Proposed Site Layout Plan

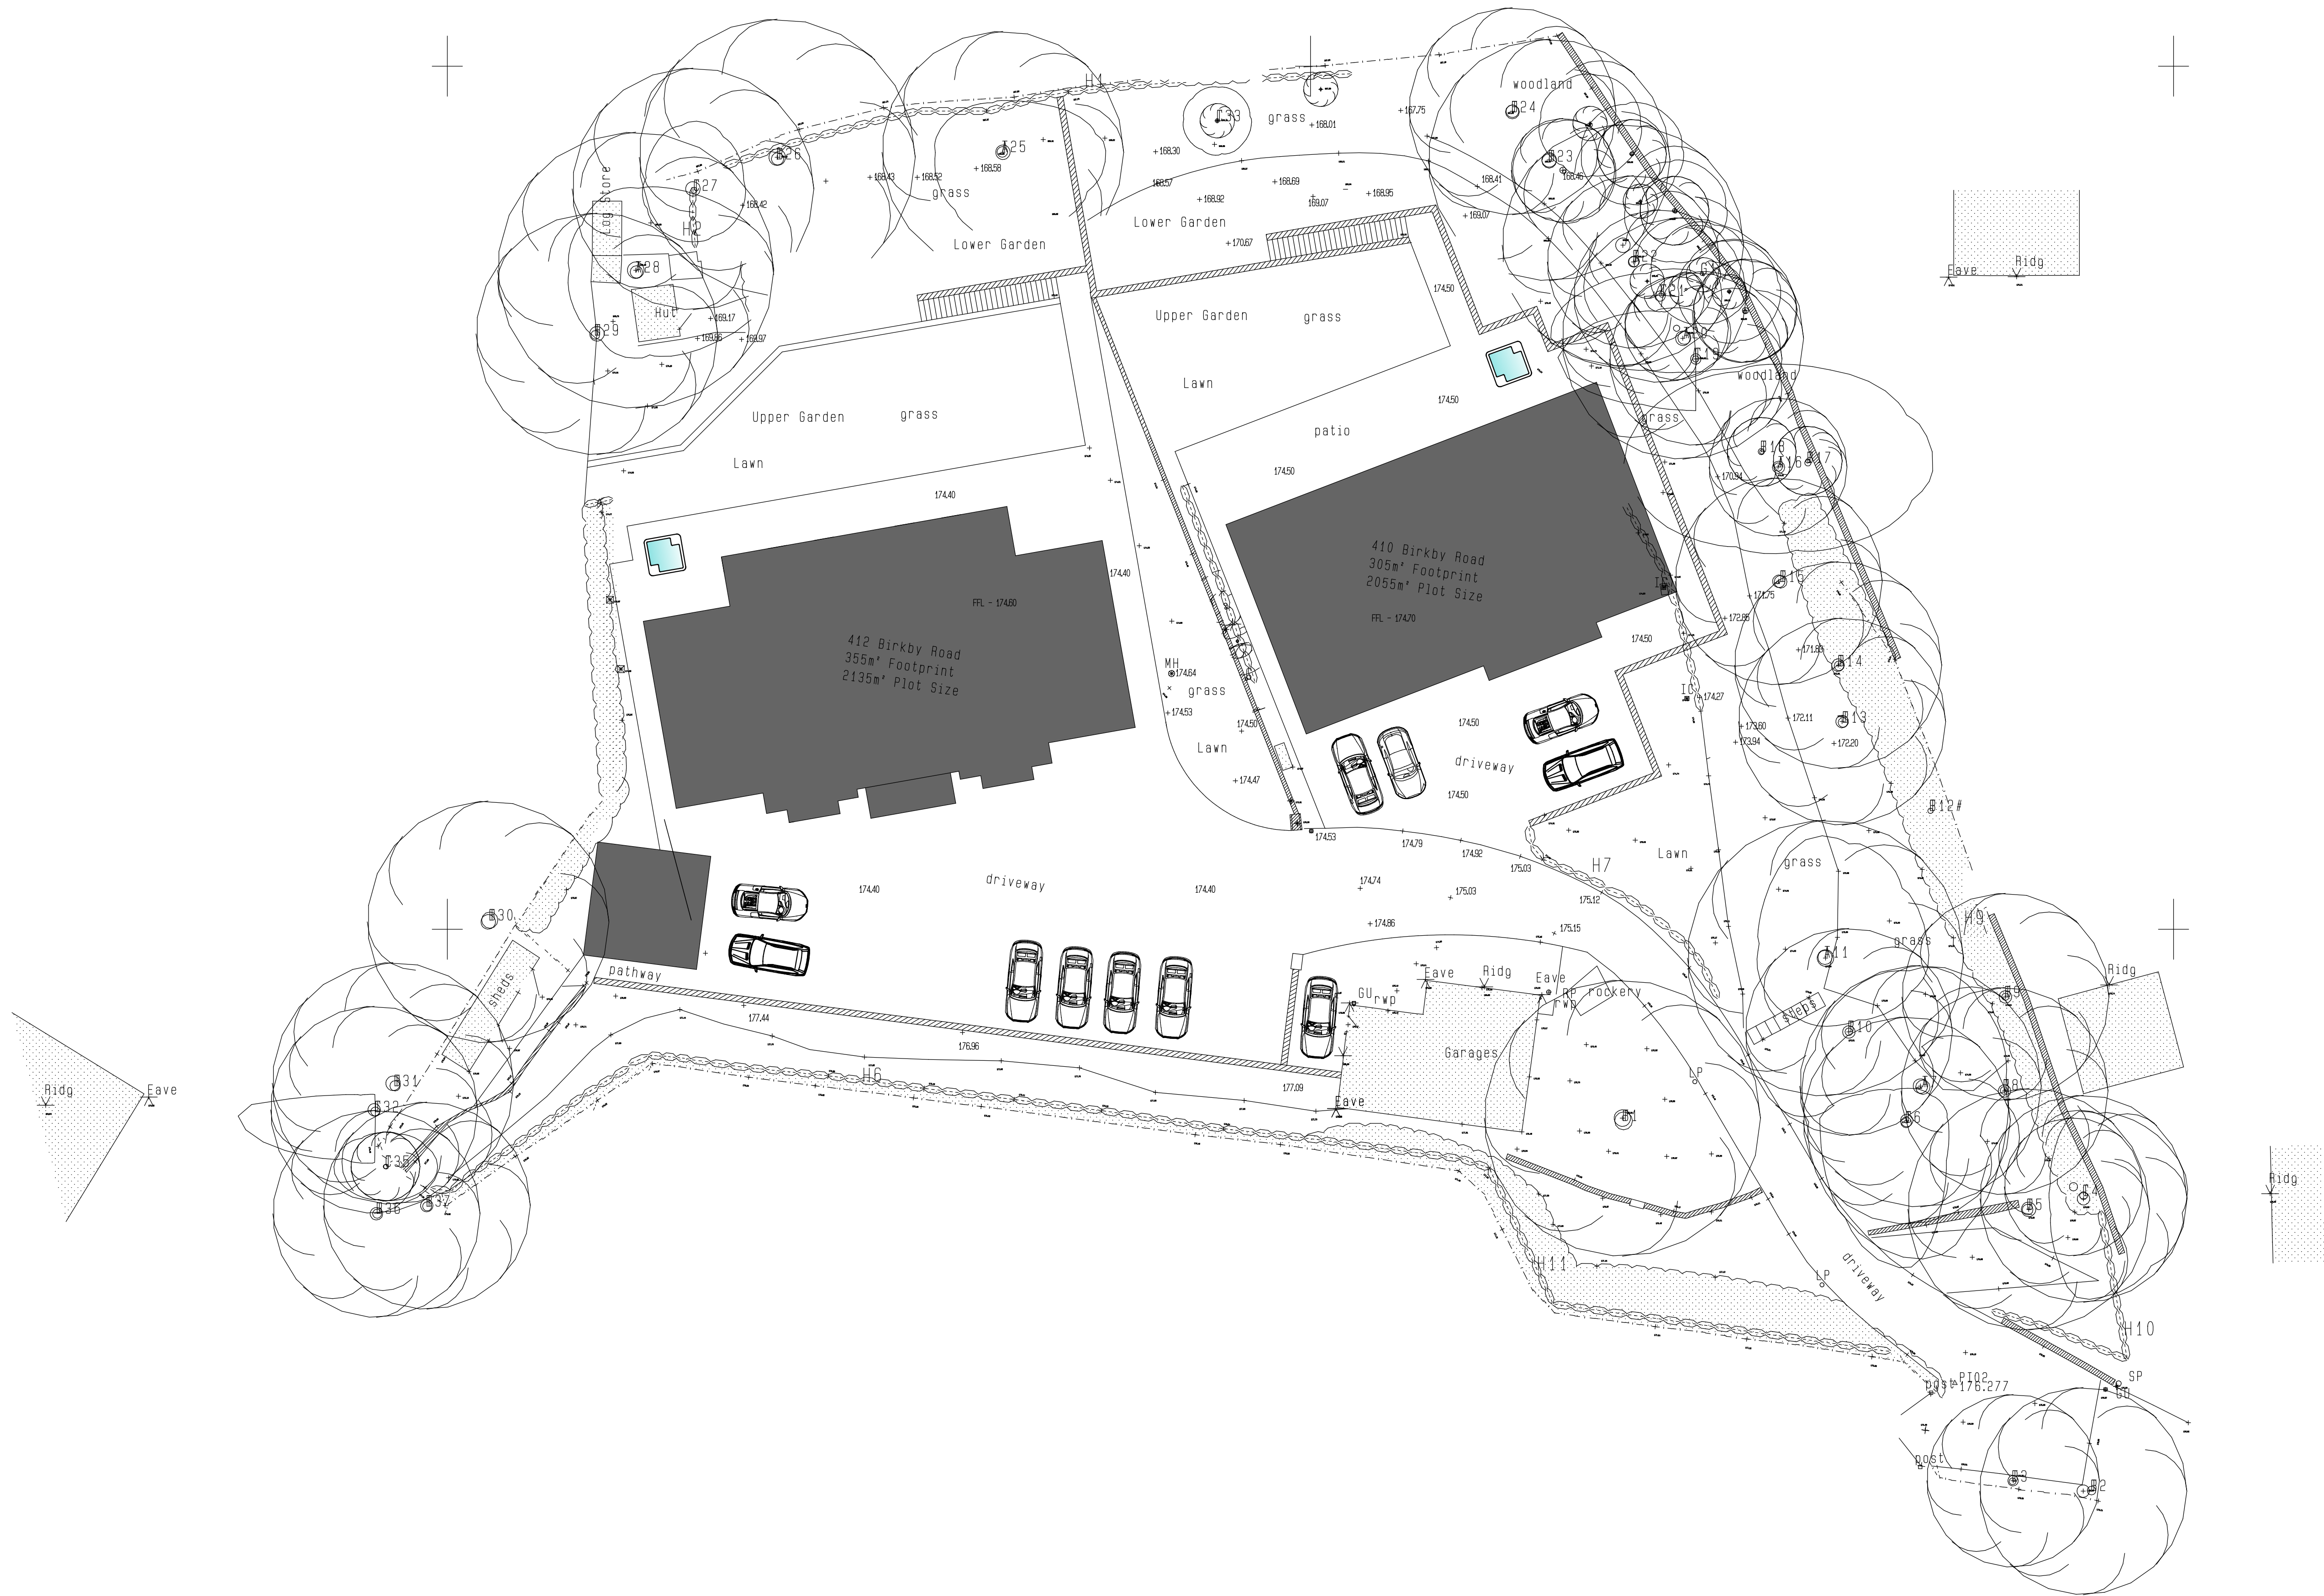
This red hatched area is coterminous with the eastern wall of the current bungalow and any building beyond that will breach this condition. The new footprint of the replacement house encroaches significantly into this red area, and beyond that there would be a retaining wall.

The location of the proposed garage/office at 412 is also within the spread of protected trees.
